BOLTON-BY-BOWLAND, GISBURN FOREST & SAWLEY PARISH COUNCIL

PLANNING APPLICATION NO:.....0091.....

RELATING TO.....HOLDEN COUGH Nurseries.....

Planning Application 3/2013/0091 Holden Clough Nursery

SJ Bialecki Limited Building Surveyors
Drawing no 7007
Scale 1:200
Proposed Site Layout
Proposed Extended Car Park At Holden Clough Nursery Holden Bolton by Bowland

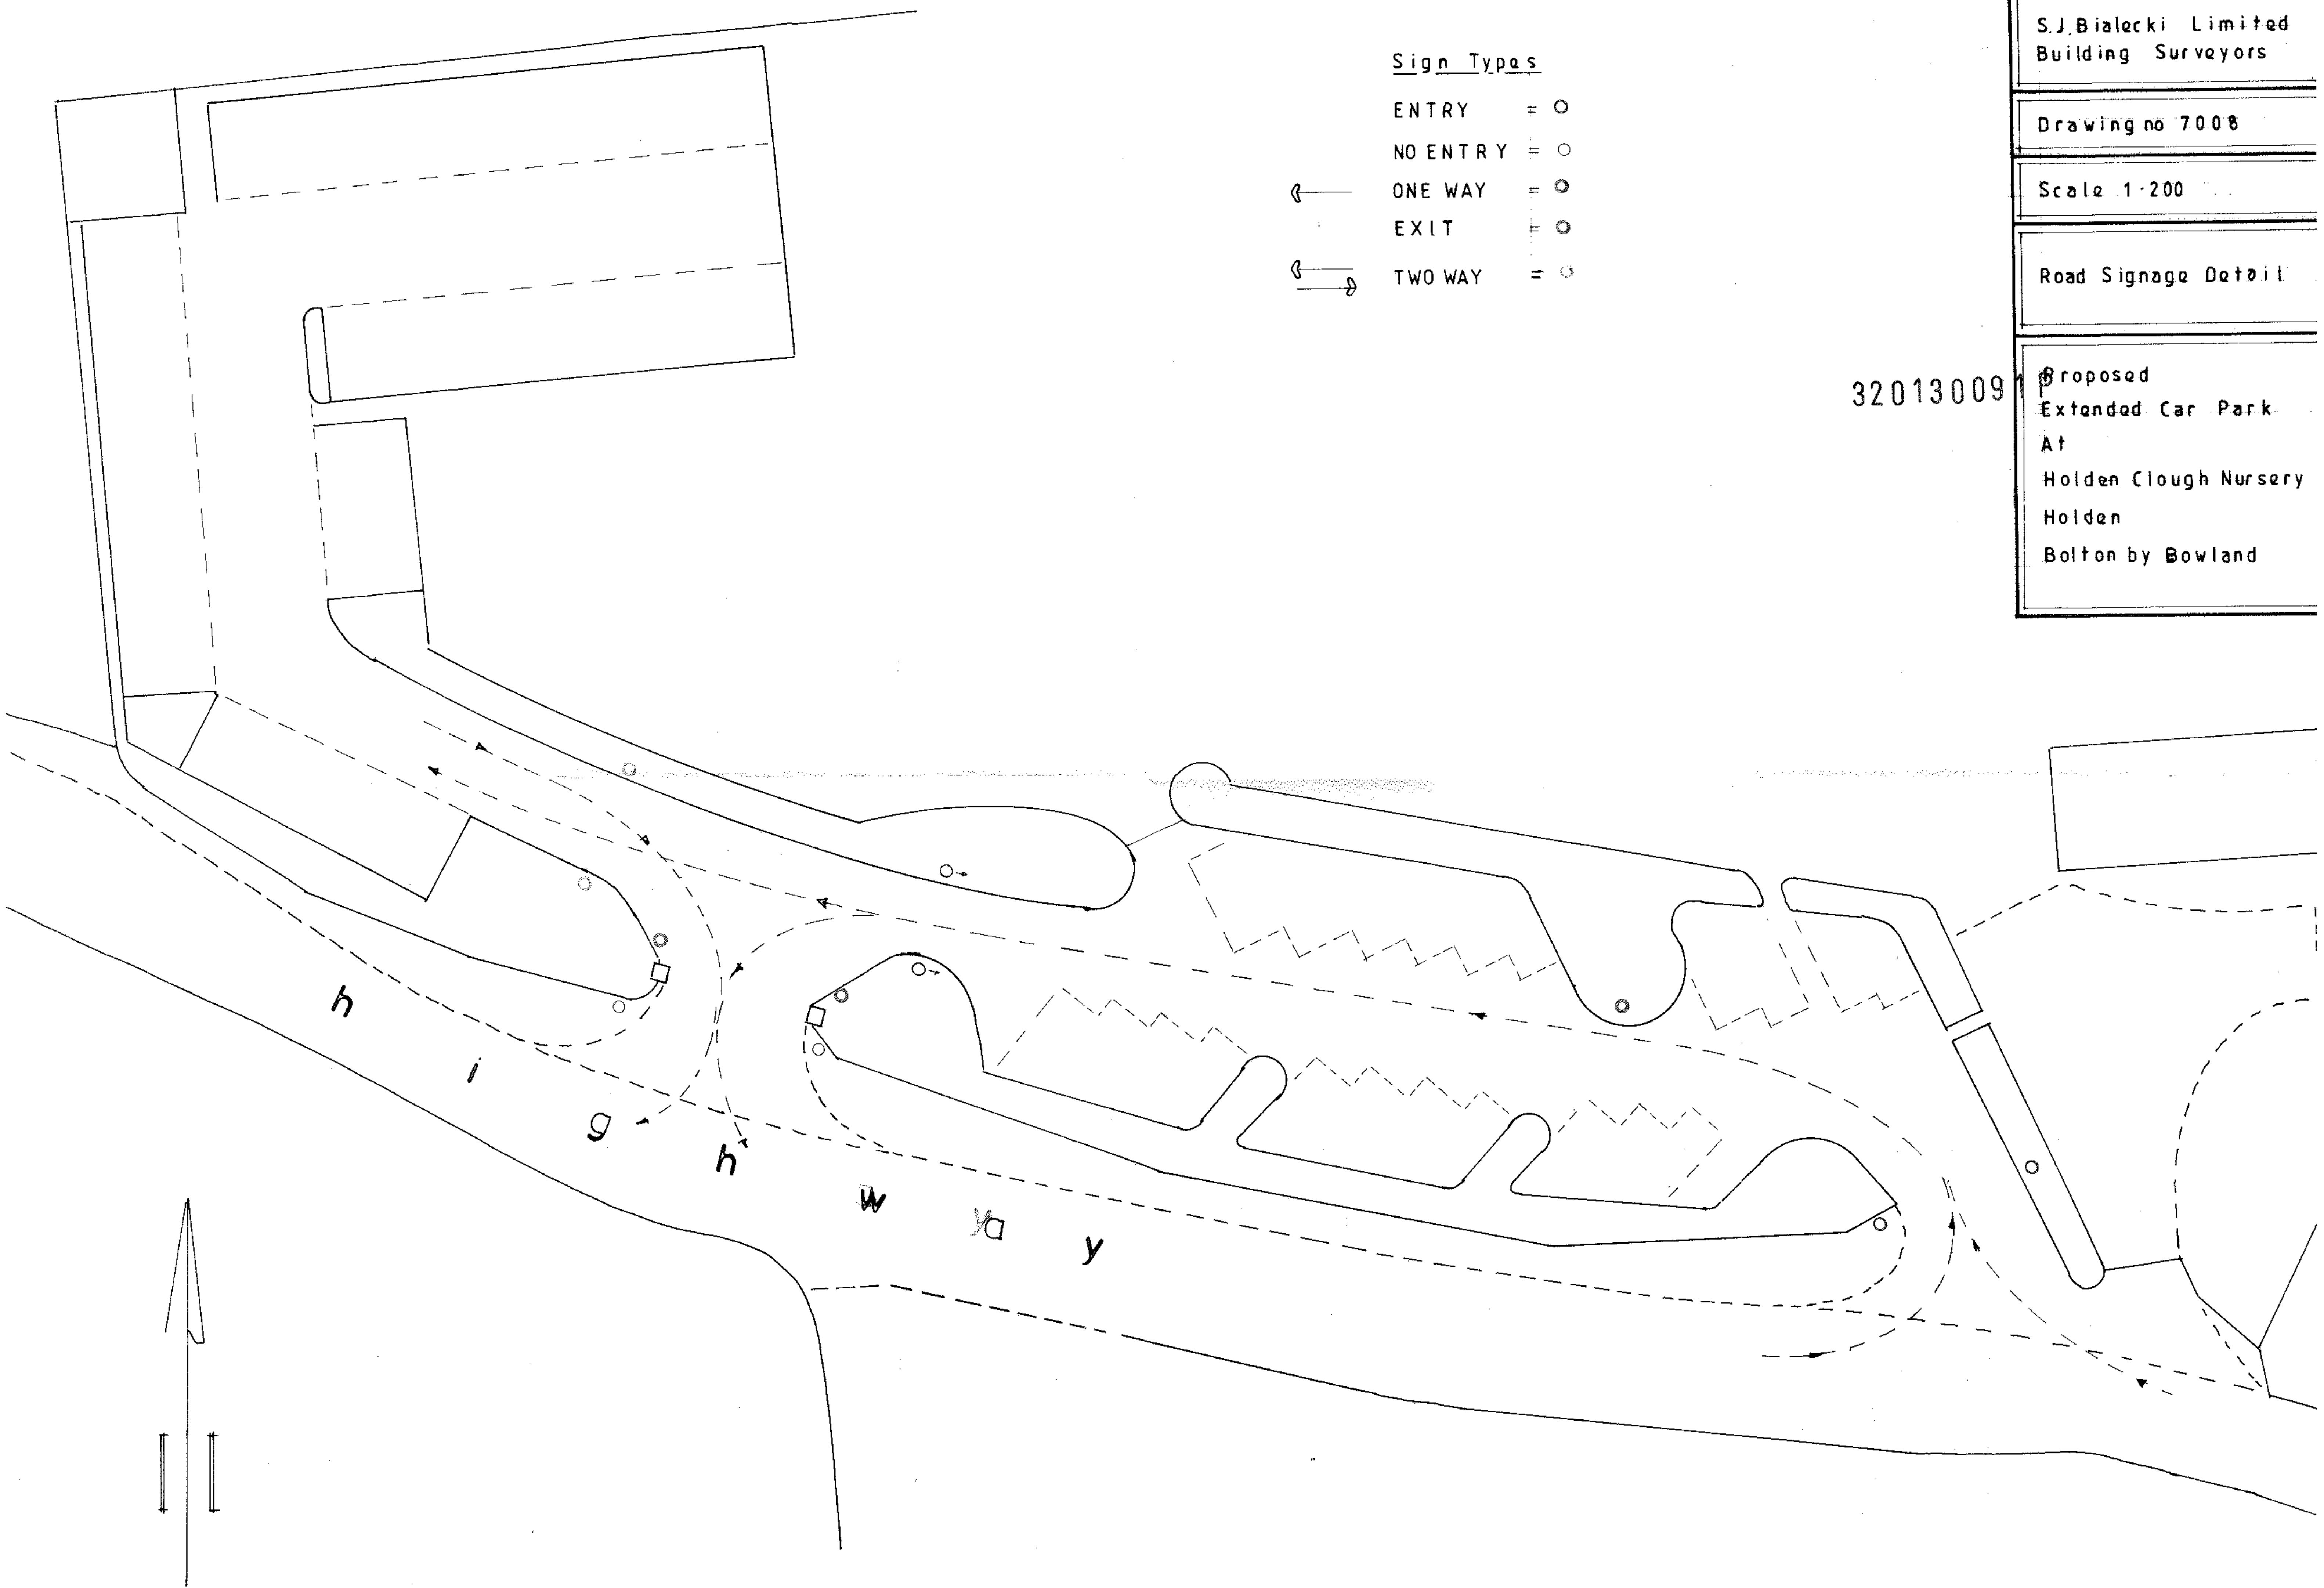
1. It is our understanding that the original plans and submission suggested minimal impact from vehicular movement. The original application provided for 22 car parking spaces. The new application requests an additional 42 spaces. This is a significant increase and must impact on the local community.

Would permission have been granted had the original application called for 64 car parking places?

2. The cafe, lecture room and ancilliary facilities have yet to be opened. The existing car parking may well be sufficient to cope with demand. Would it be sensible to see the extent of demand and provide accordingly? We think the Nursery would have a much stronger case if it could be shown that current provision does not meet demand.
